From: Neville, Julie <Julie.Neville@lancashire.gov.uk>
Sent: 02 April 2025 17:38
To: Planning
Subject: 3/2025/0093 - 1 2 3 Skirden Lodge Wigglesworth Road Slaidburn BD23 4SX
Attachments: 3 2025 009 Overlay.pdf

Reference 3/2025/0093
Location 1 2 3 Skirden Lodge Wigglesworth Road Slaidburn BD23 4SX
Proposal Alterations to existing building with nil use to form a 2 bedroom dwelling with car parking, garden curtilage and hard and soft landscaping.

document date:
28/01/2025
document stage:
PLANNING
drawn by: RH
checked by: RH
sheet name:
Proposed Site Plan

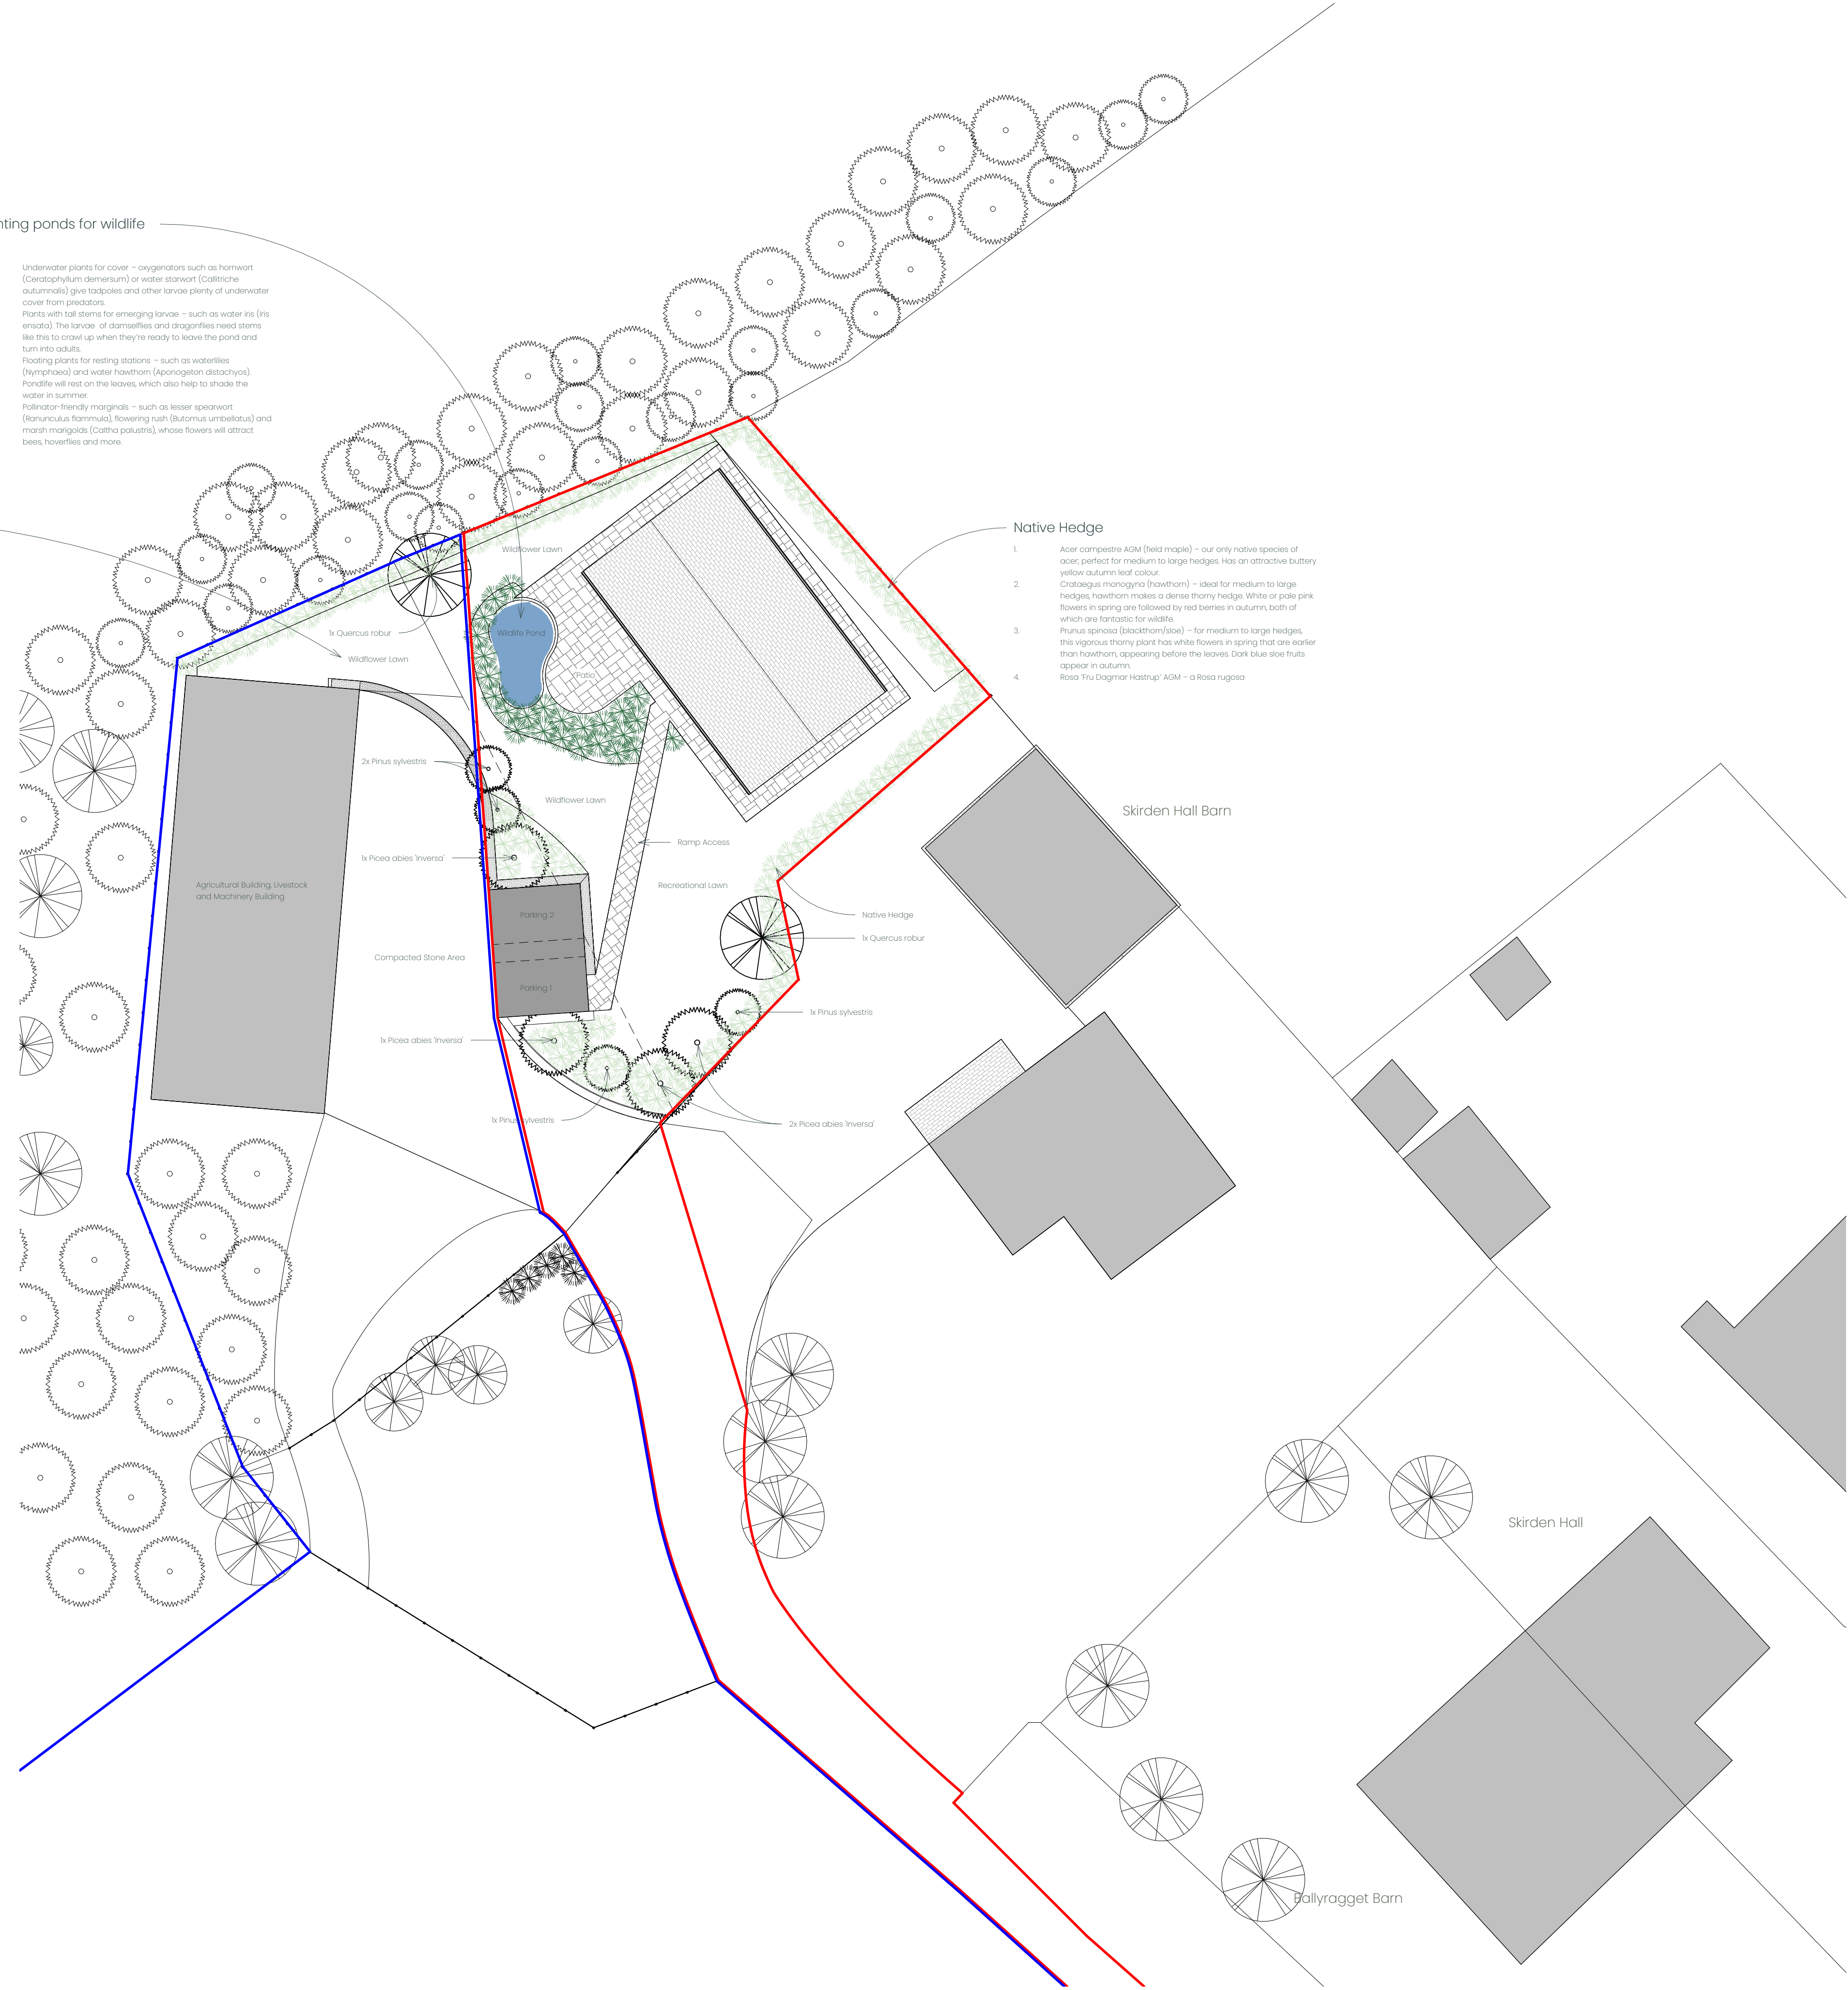
Lancashire County Council Public Rights of Way Team raises no objection to be above application as the development will not cause a significant effect to footpath FP0319013, as shown on the attached plan.

Any changes in ground level or installation of drainage should ensure that surface water is not discharged onto a public right of way either within the proposed development site or in close proximity – this is to ensure public rights of way are not exposed to potential flooding or future maintenance issues.

Any trees or bushes should to be at least 3 metres away from a public right of way to prevent any health and safety issues and potential maintenance issues e.g. Overhanging branches or roots coming through the surface of the footpath concerned either within the proposed development or in close proximity.
